Arun District Council
Arun Civic Centre
Maltravers Road
Littlehampton
West Sussex BN17 5LF
Planning & Building Control General Enquiries
Tel: (01903) 737756 Fax: (01903) 730442
Dx: 57406 Littlehampton
Minicom: 01903 732765
e-mail: planning@arun.gov.uk
website: www.arun.gov.uk/planning

Application No: A/193/20/PL
Site Address: Ham Manor Cottage Ham Manor Way Angmering BN16 4JQ
Description of works: Erection of a 1 No. 3 bedroom chalet bungalow & detached garage. This site is in CiL Zone 3 and is CIL Liable as dwelling.

Proposed Street Scene (Scale 1:200)

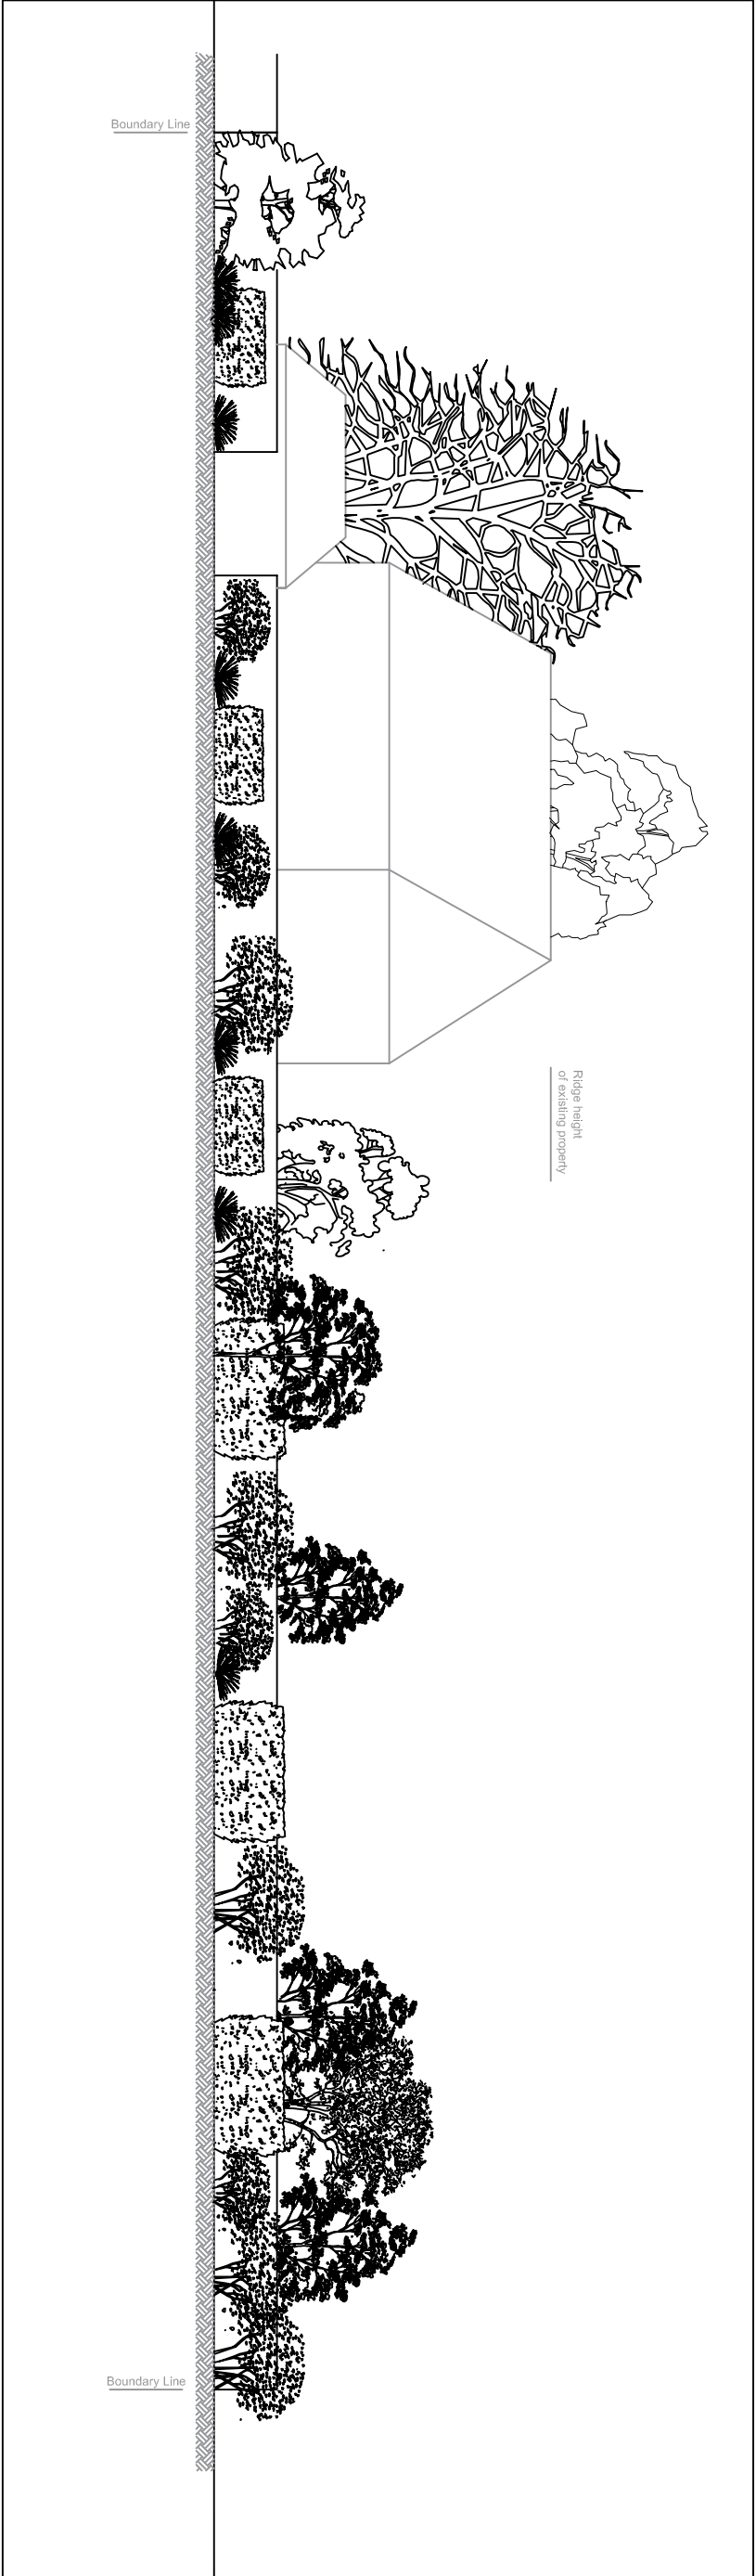
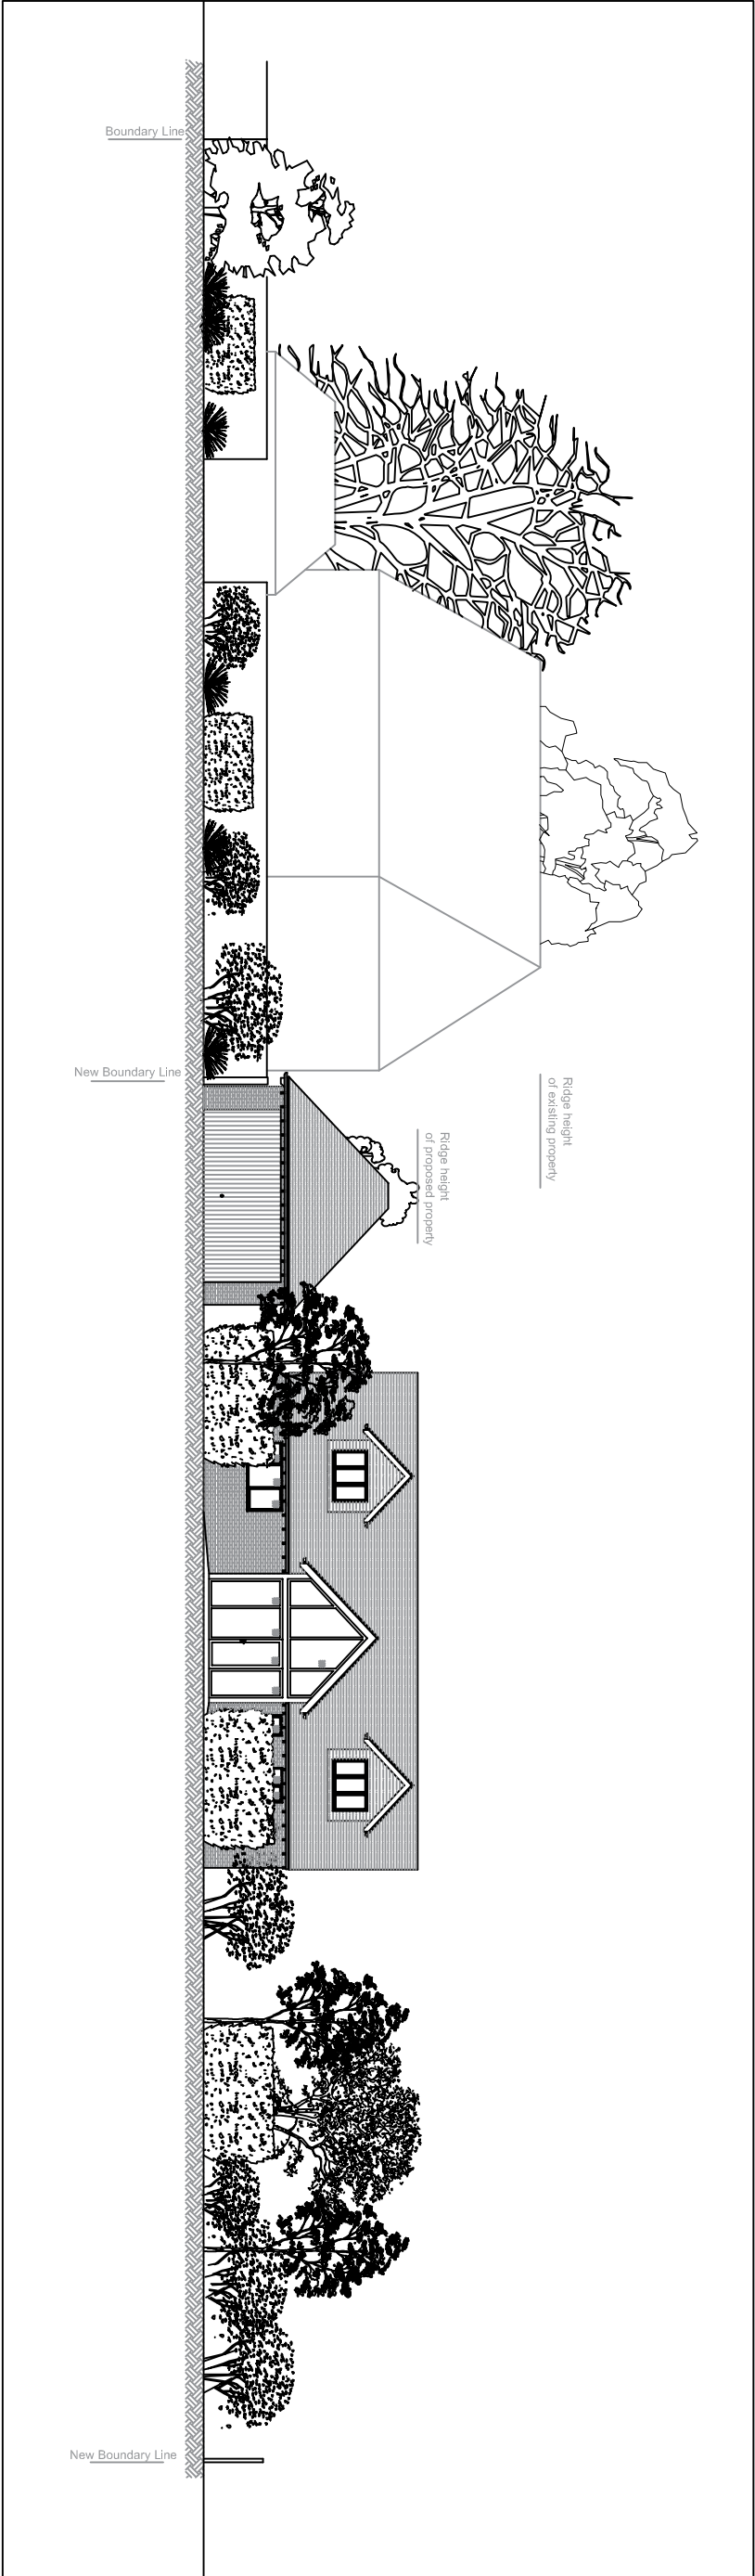
The submitted plans indicate that the majority of the footprint of the proposed dwelling would be in front of the building line of this eastern length of Ham Manor Way. This layout is not characteristic to this area and would conflict with:-

Revision:	A	Dec 2020	Dimension added
address	Ham Manor Cottage, Ham Manor Way, Worthing, West Sussex		
project	Proposed construction of 3 bedroom detached property with detached double garage		
title	Proposed Block Plan		
scale	date	dwg no.	revision
1:200 on A4		2020.275.02	A

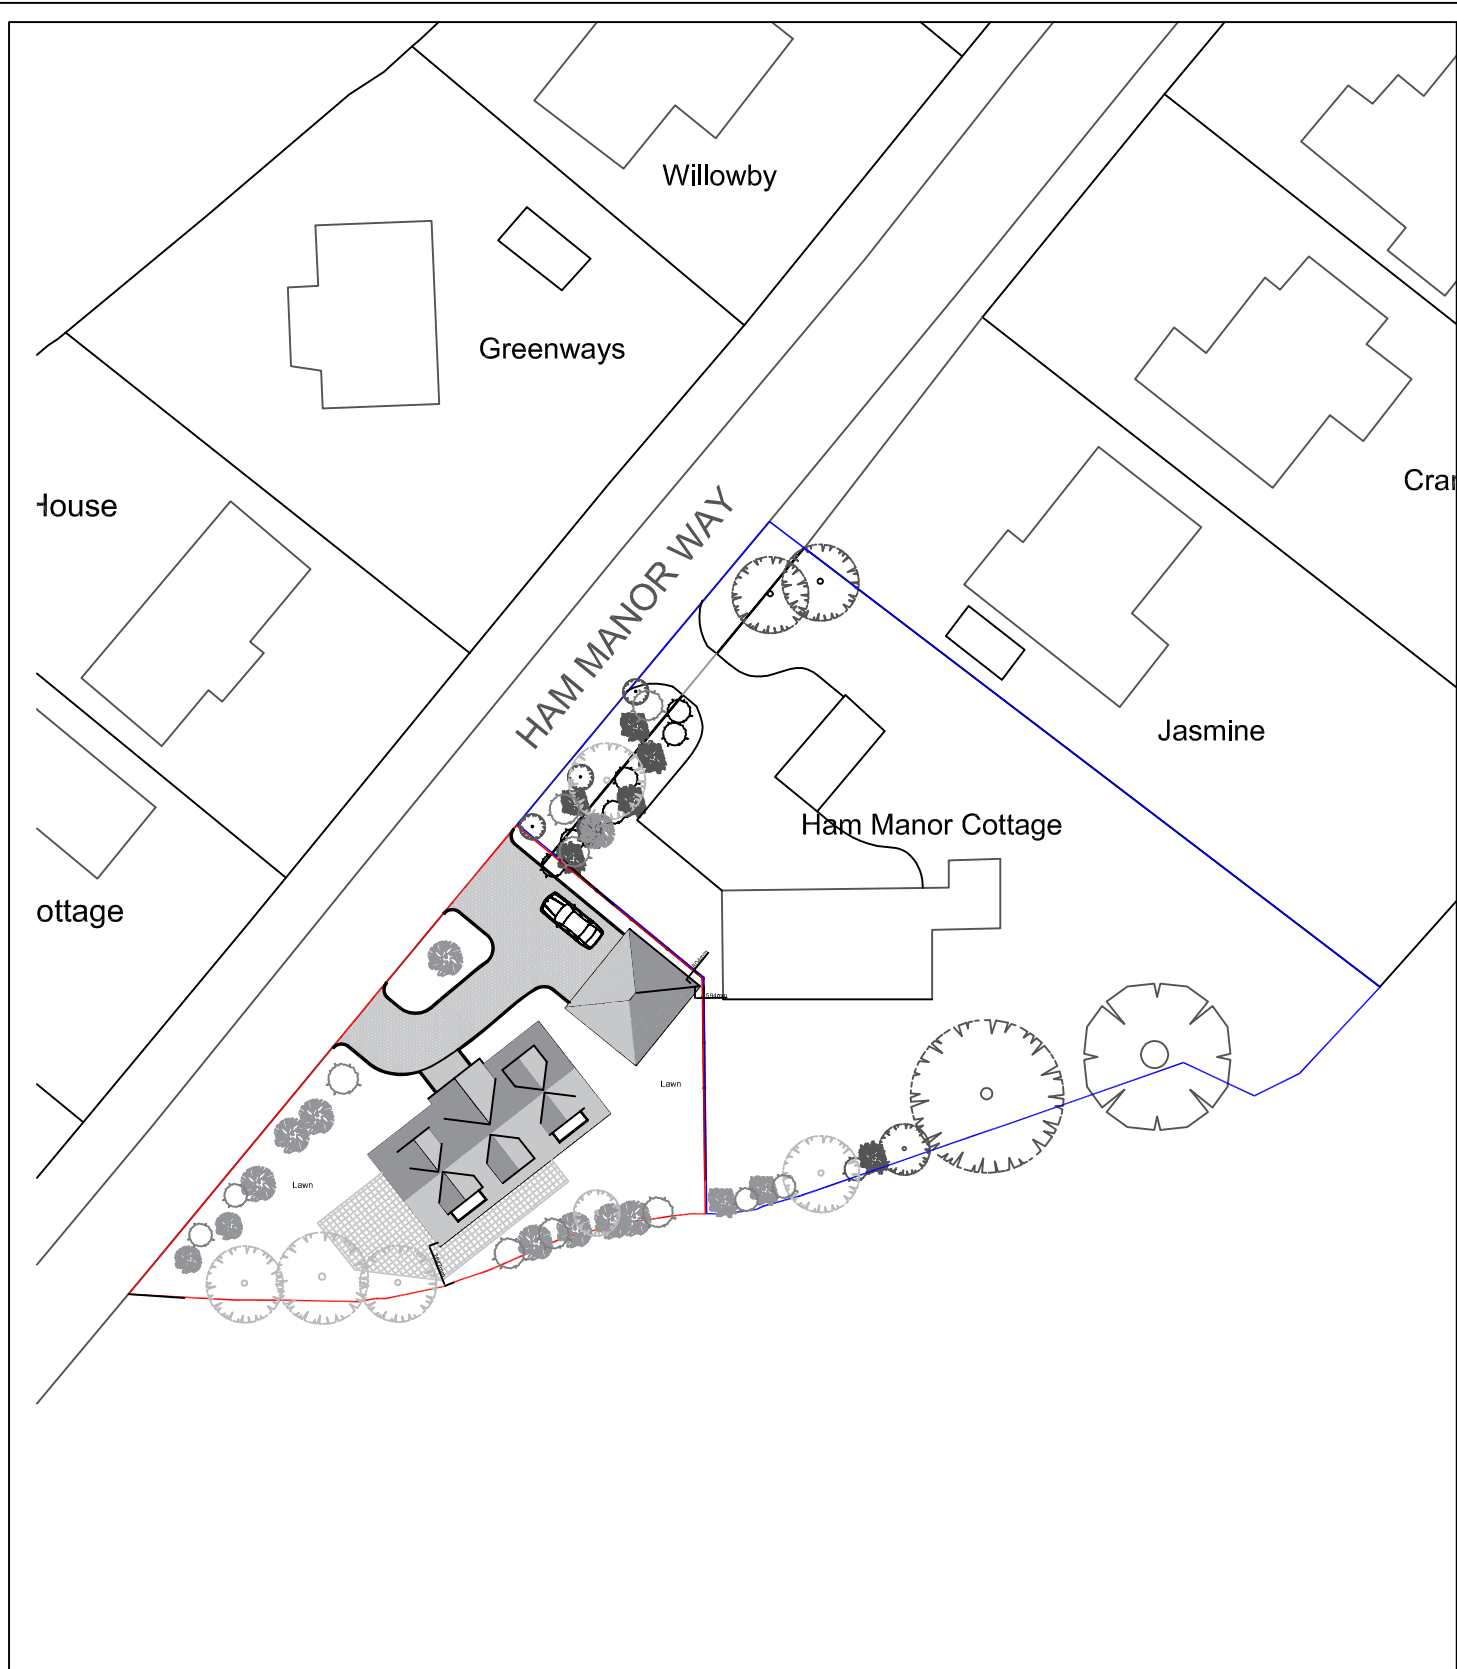
- Arun's adopted Local Plan Policy D SP1
- Arun's Design Guide Section M Pages 114 and 116
- Angmering's Neighbourhood Plan Policy HD5
- Nationally accepted guidelines
